Precinct Village and Car Park

Value Management package

Sydney Football Stadium Redevelopment Design Integrity Panel Presentation

Minutes of the Precinct Village and Car Park VM Design Presentation held on Monday 6 December 2021 via Microsoft Teams.

DRAWING  
PLANT MIX A: CARPARK PLANTING

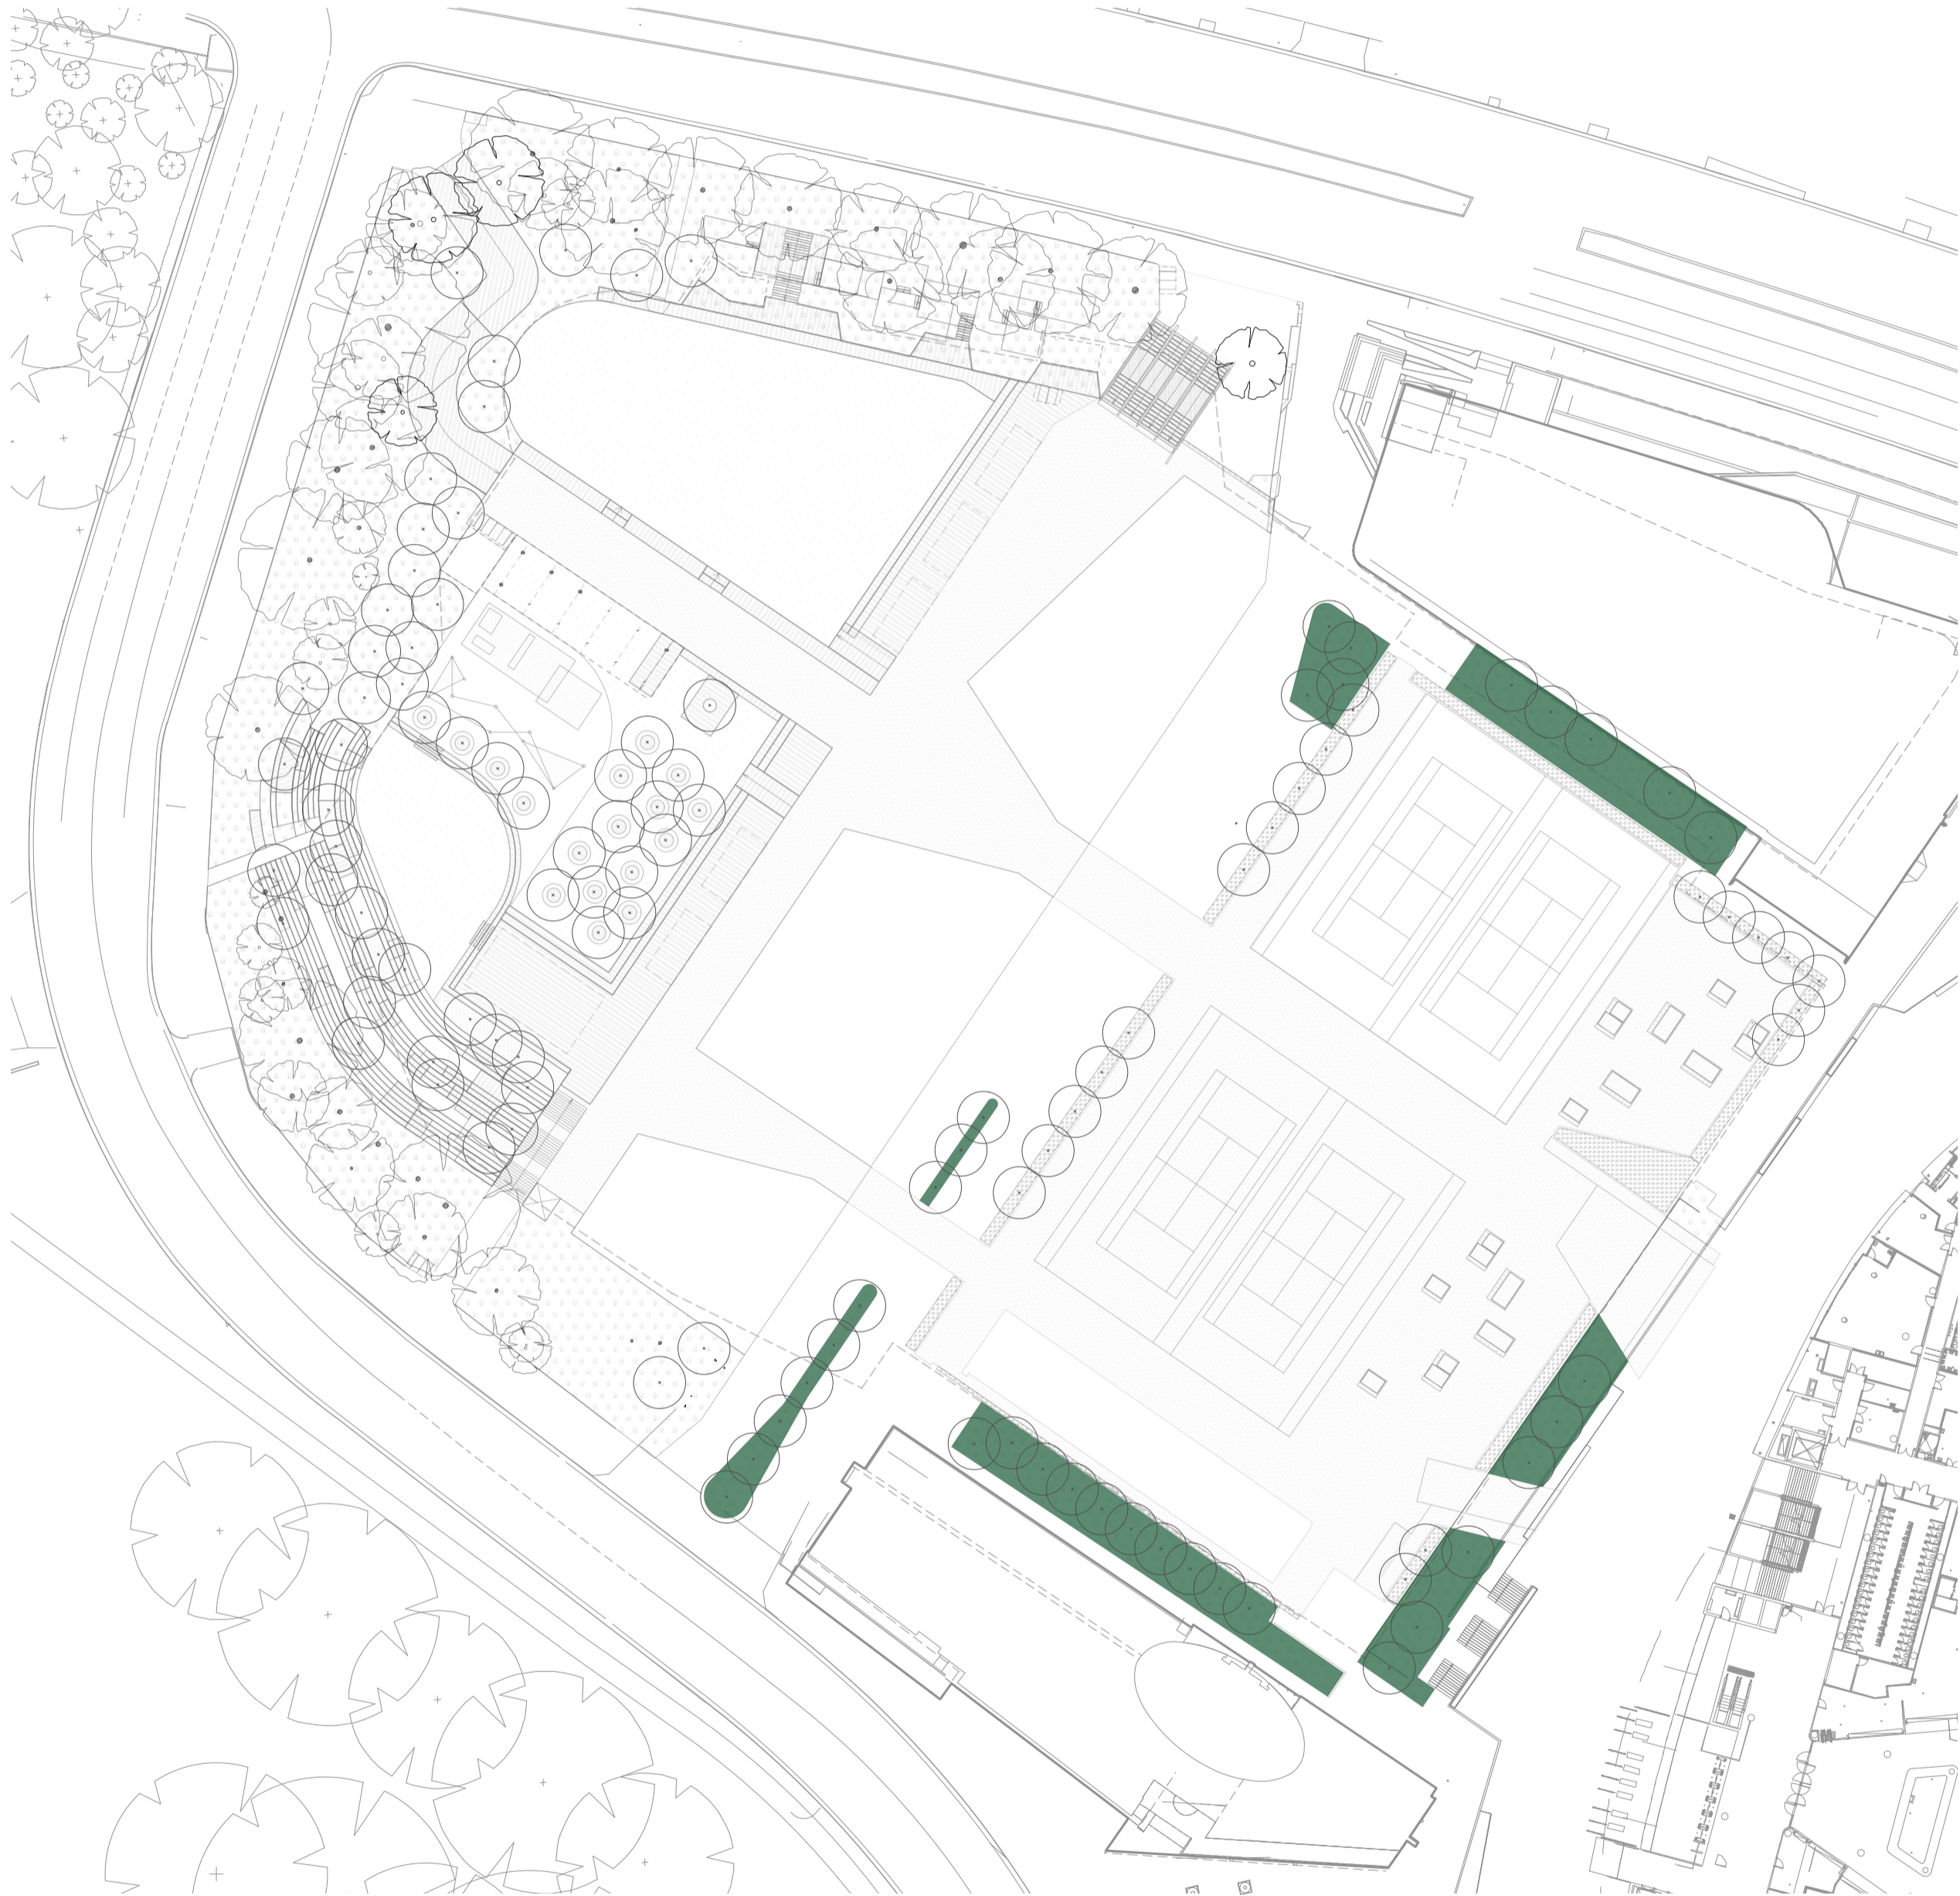
- PP noted that there could be further investigations with regards to the landscaping details to dial up the landscaping to these elevations within the GRC planters to soften the façade.

-
- TG summarised and the DIP concurred that the removal of the “hit & miss” brickwork would be supported noting that Aspect Studios would need to refine the landscape design to the planters to ensure that it softens the facade. It was further discussed that investigation of stainless steel mesh and vines be undertaken. Aspect should advise best fit for landscape screening and on-going maintenance,

A30.EW.02

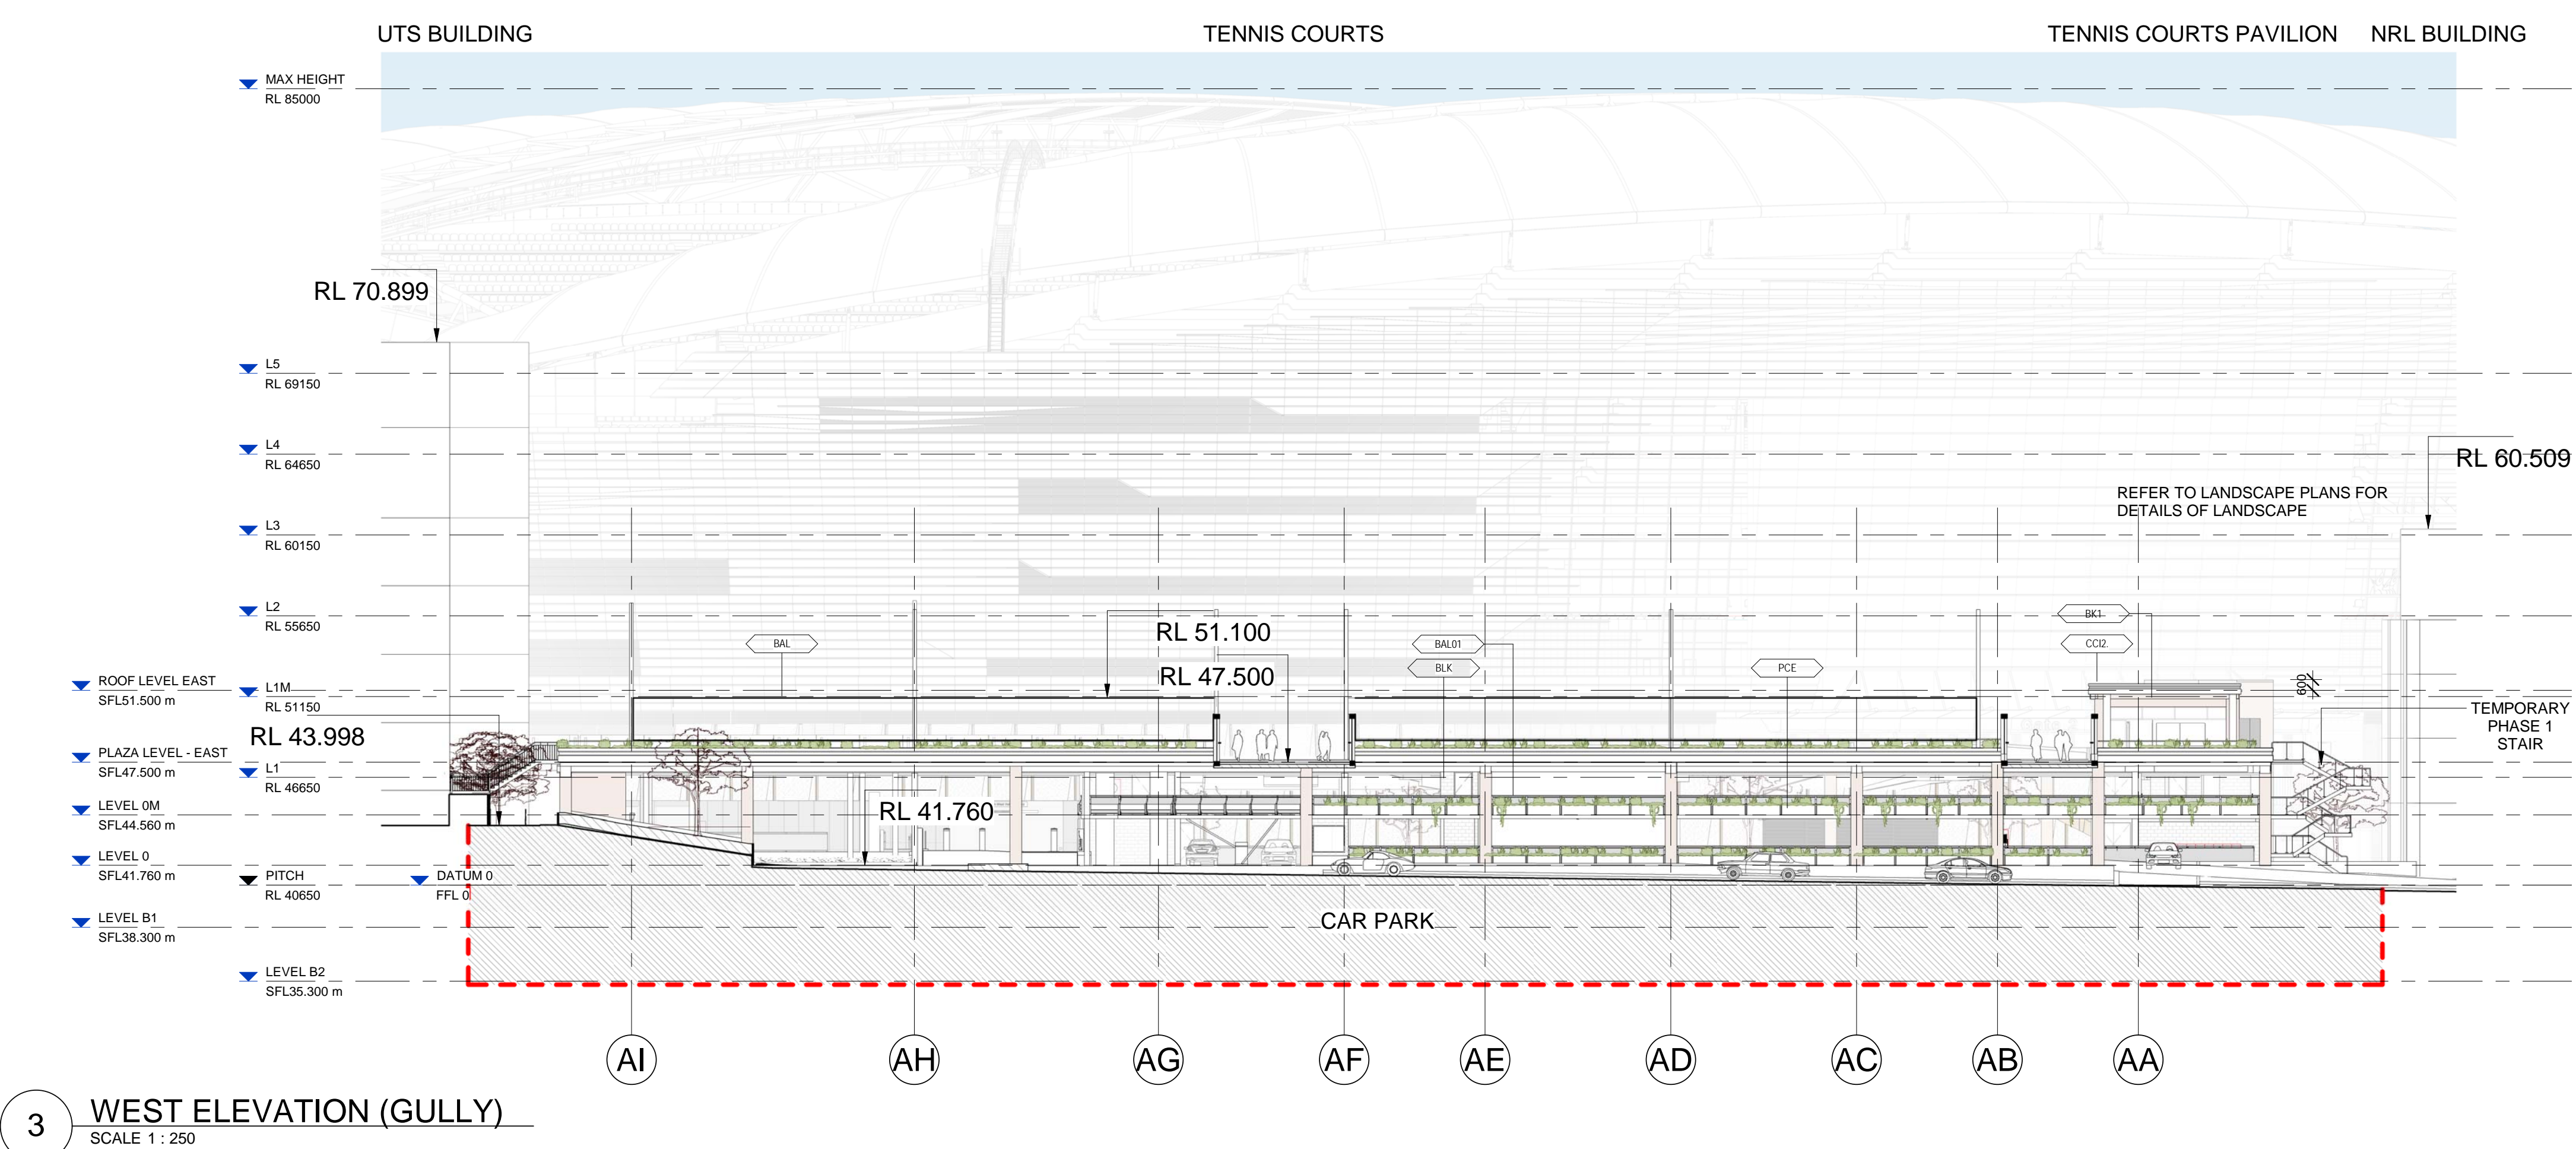
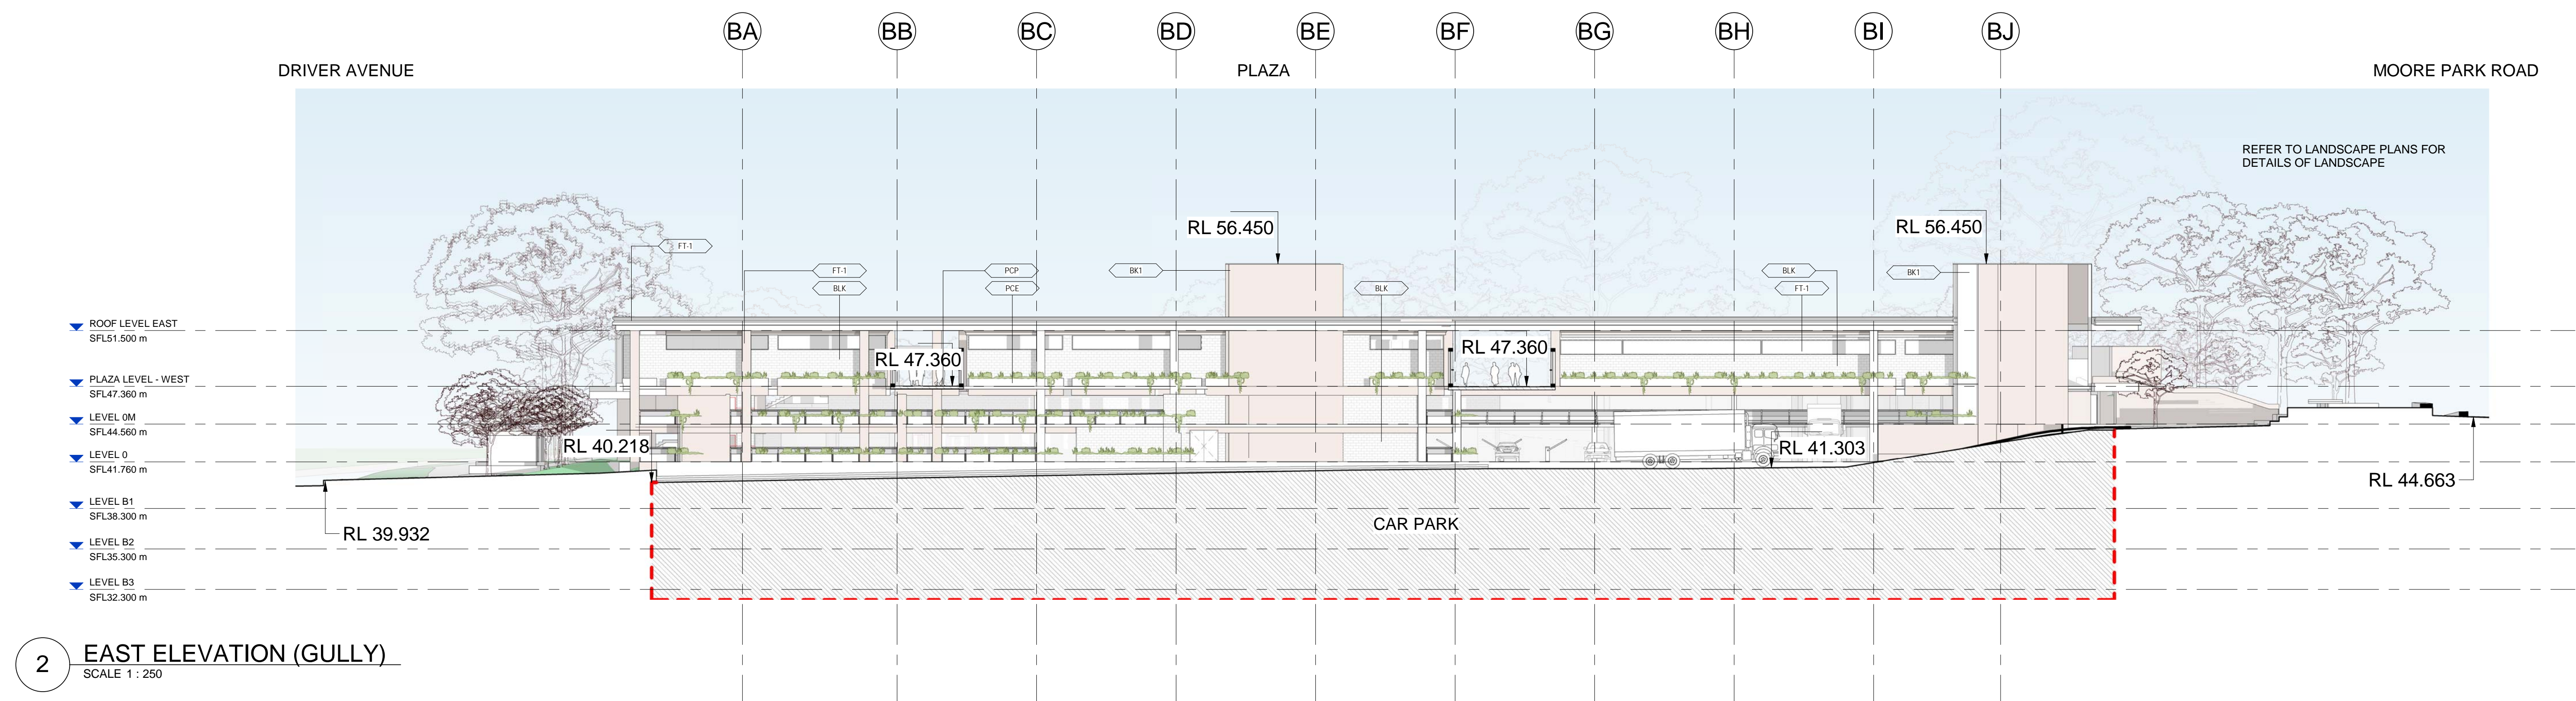
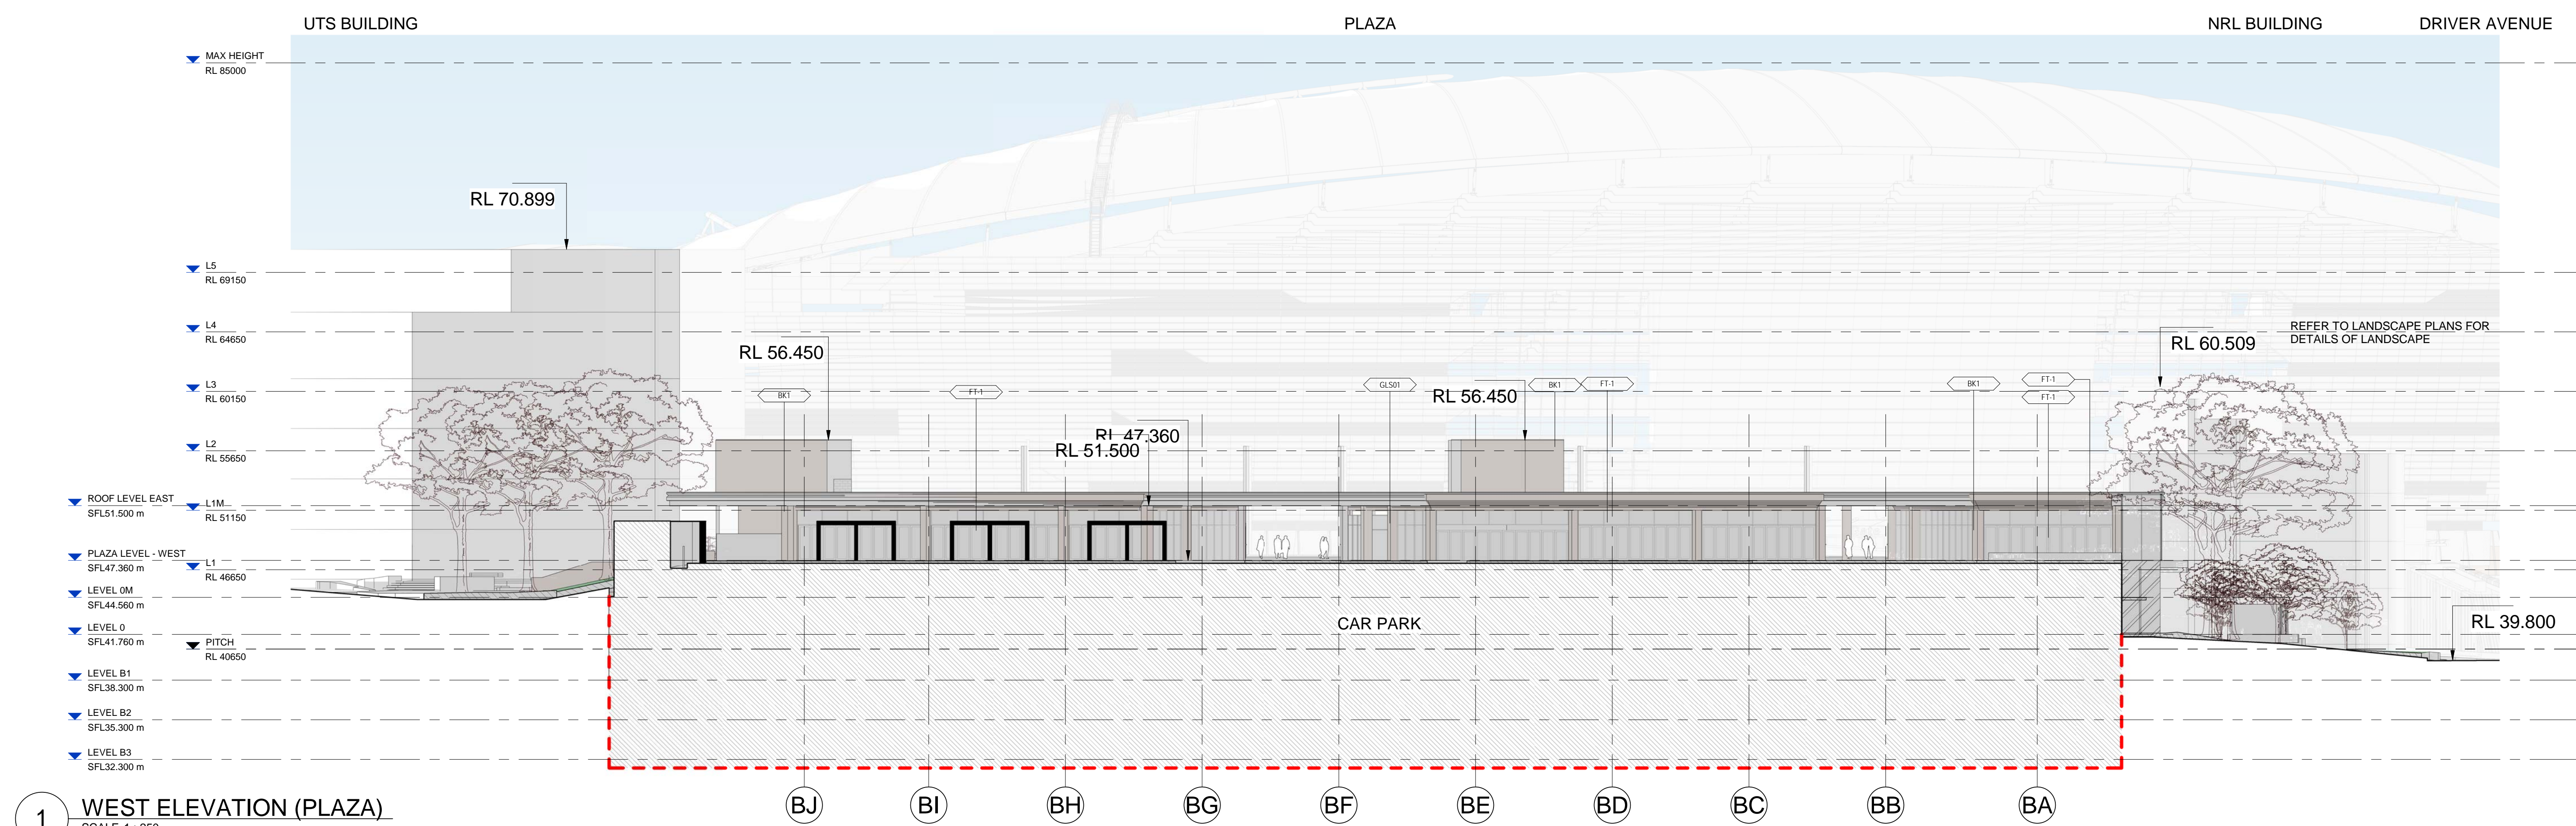
- KC queried whether the SSDA submission option with “hit & miss” brickwork required the crash barrier or guard rail to be added. AY/JA confirmed that the guard rail is required as the guard rails replace the original in-situ planters which are proposed to be lightweight GRC planters in the proposed alternative option. AY/JA further note that screens or other forms of barriers are required to stop both people from falling and vehicles, and both planter boxes and softwalls are not high enough for the purpose of preventing people from falling, requiring guard rails to all elevations.

- PP queried if all the “hit & miss” brickwork and the planter boxes are to be removed in the option. AY confirmed the planter boxes to the south and east façade are to be removed, but planter boxes on the gulley are to be maintained but replaced with the lightweight GRC planter boxes. AY further confirmed that vehicle barriers and guard rails are still required where planter boxes are used.

- KC noted that the changes need to be the best application of saving versus retaining a strong design intent particularly to façade elements.
- TG queried who will see the changes to the carpark façade in the option. AY confirmed on the south and the east side will be the most evident locations, and the west design is still maintaining the green softening and the brick as much as possible.

- TG noted that the retention of the brick portal frames does retain the connectivity with the SCG brick walls to Driver Avenue. TG further noted that there are potential issues with the “hit & miss” brickwork as it would require further development to include guard rails etc. SJ further noted that the “hit & miss” brickwork was also potentially climbable and would require additional screens.
